Your Ref: OWPC17306
Our Ref: FG/1/18/HH 05-01-2018
Please ask for:
Ross Leal

Loft conversion & rear extension
63 Midhurst Drive Ferring

DRW NO 4 SCALE 1/50 (A3)
PROPOSED ROOF PLAN

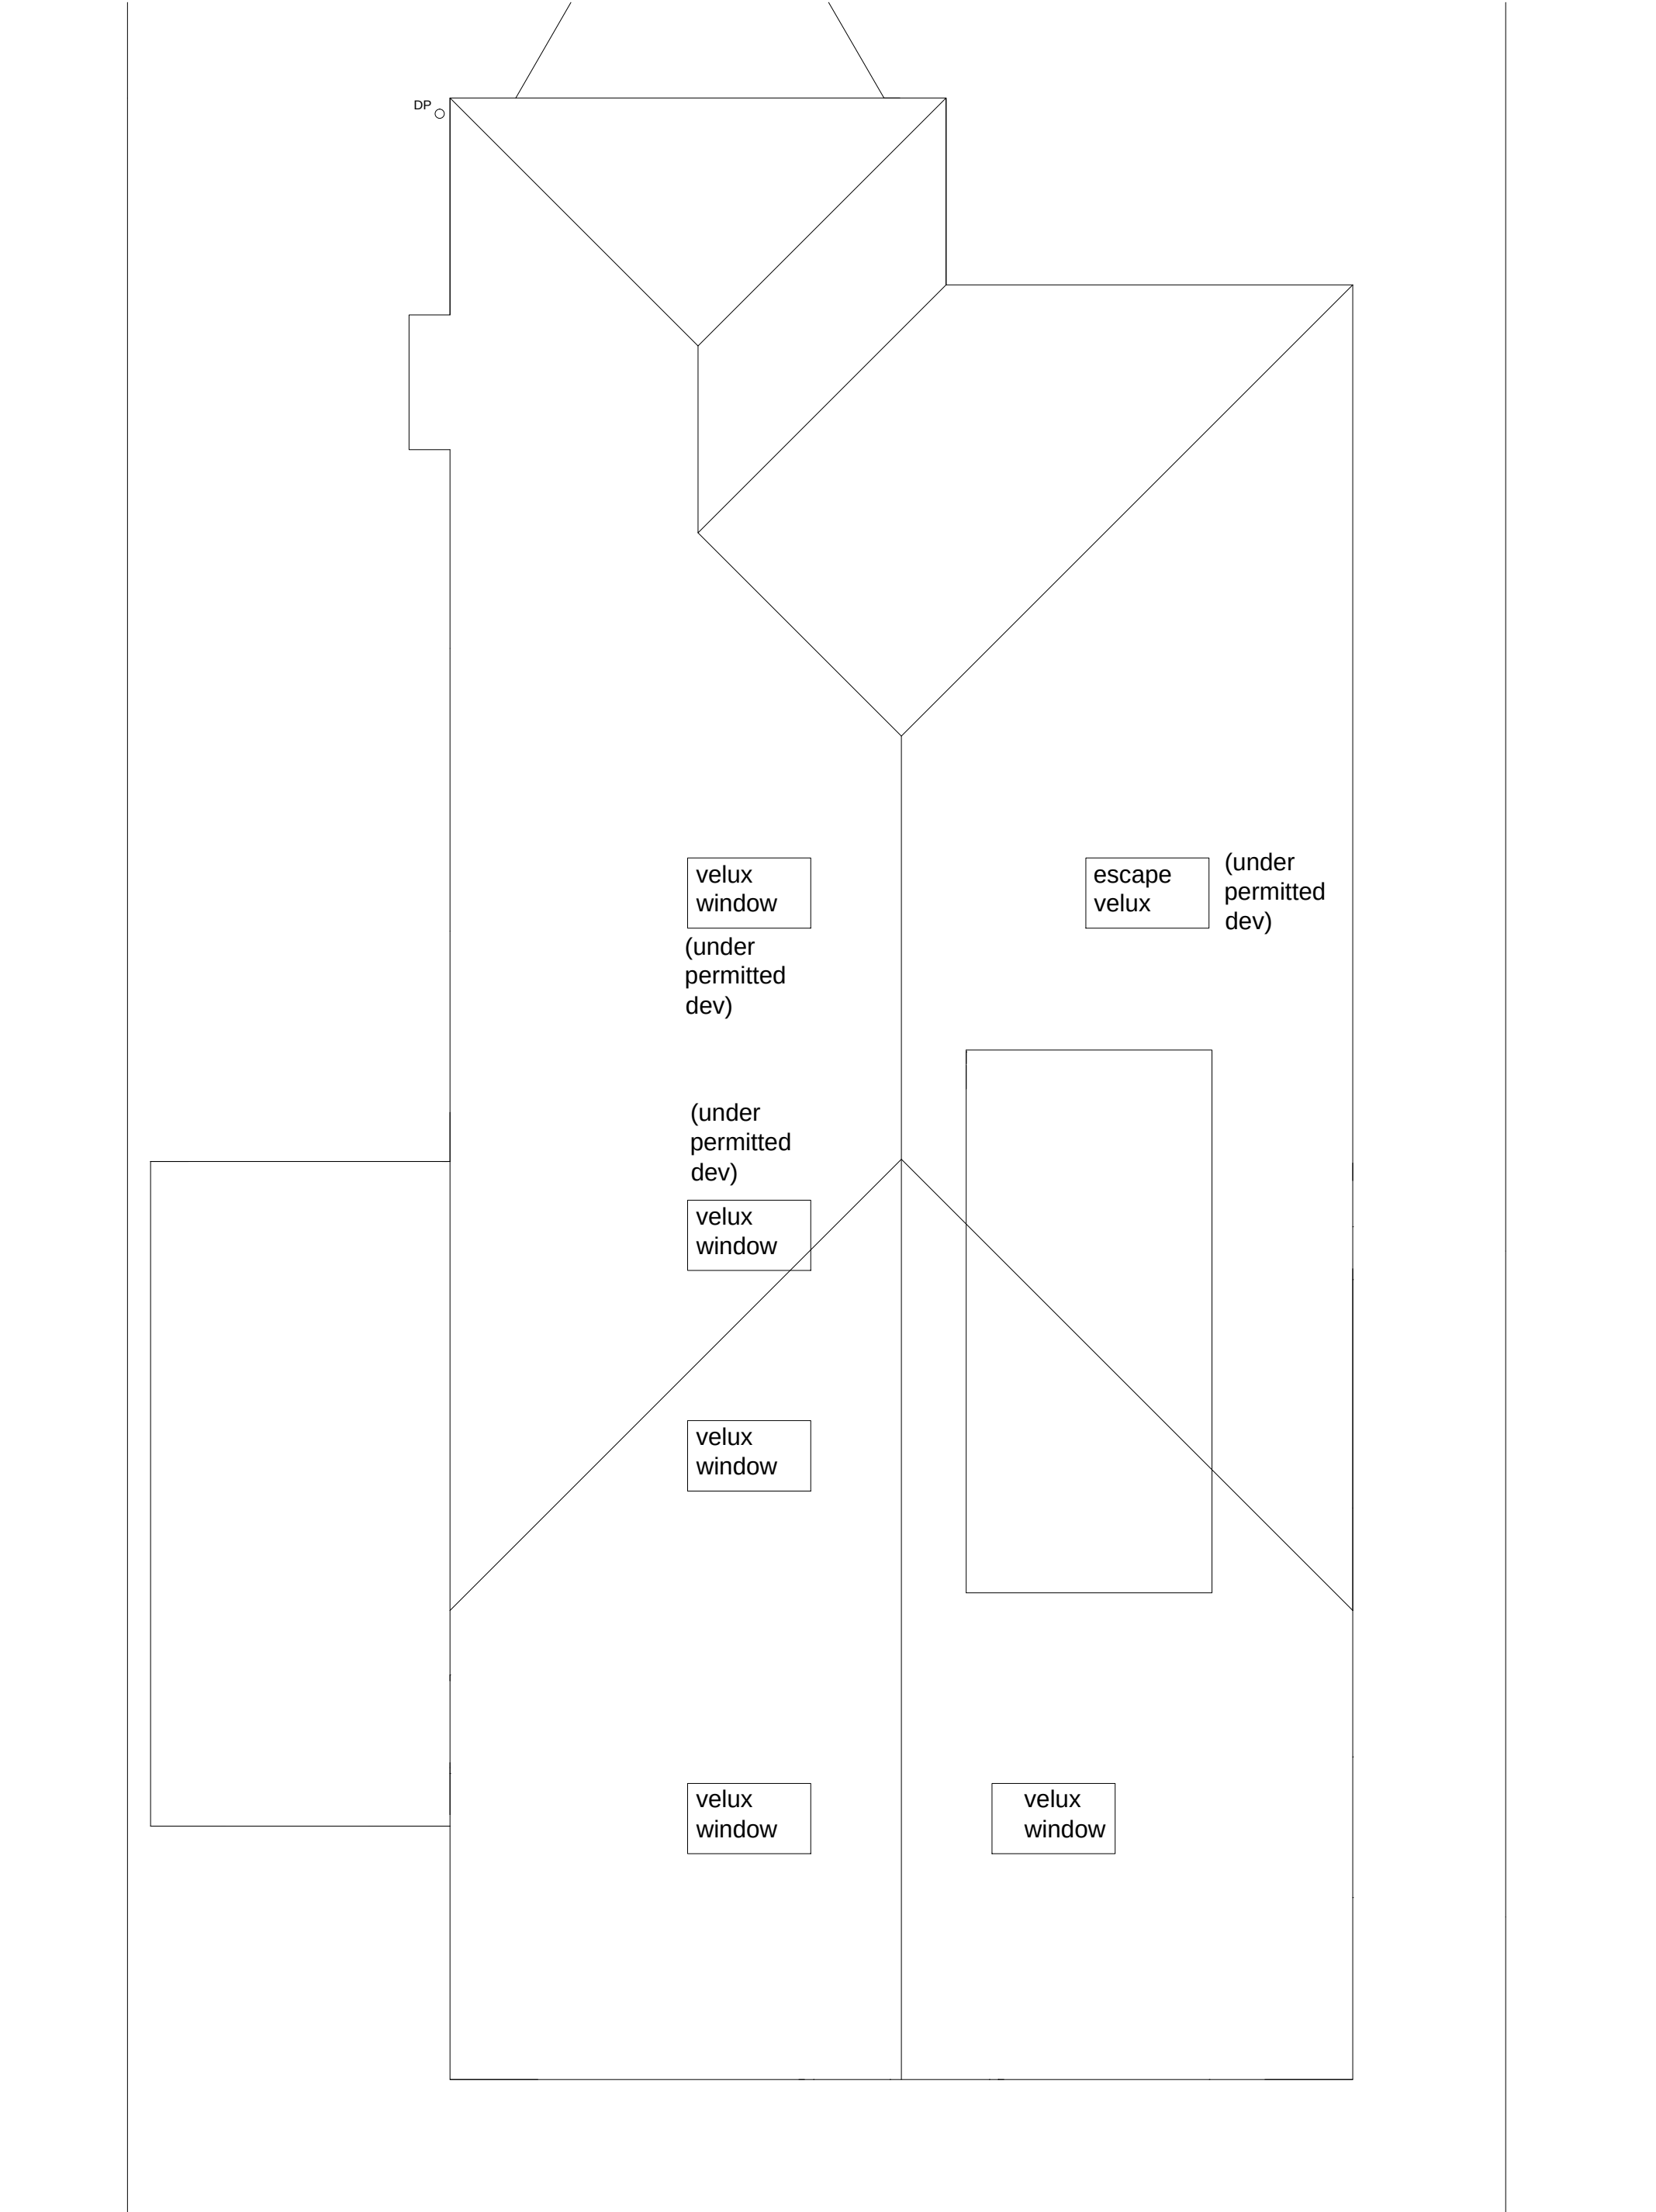
Ferring conservation group objects to this application on the grounds that it is prejudicial to the interests of the immediate neighbours - dwarfing and overbearing on the bungalow of No. 61 Midhurst Drive. There is also some degree of overlook, with the windows in the roof of the proposed first floor of No. 63.
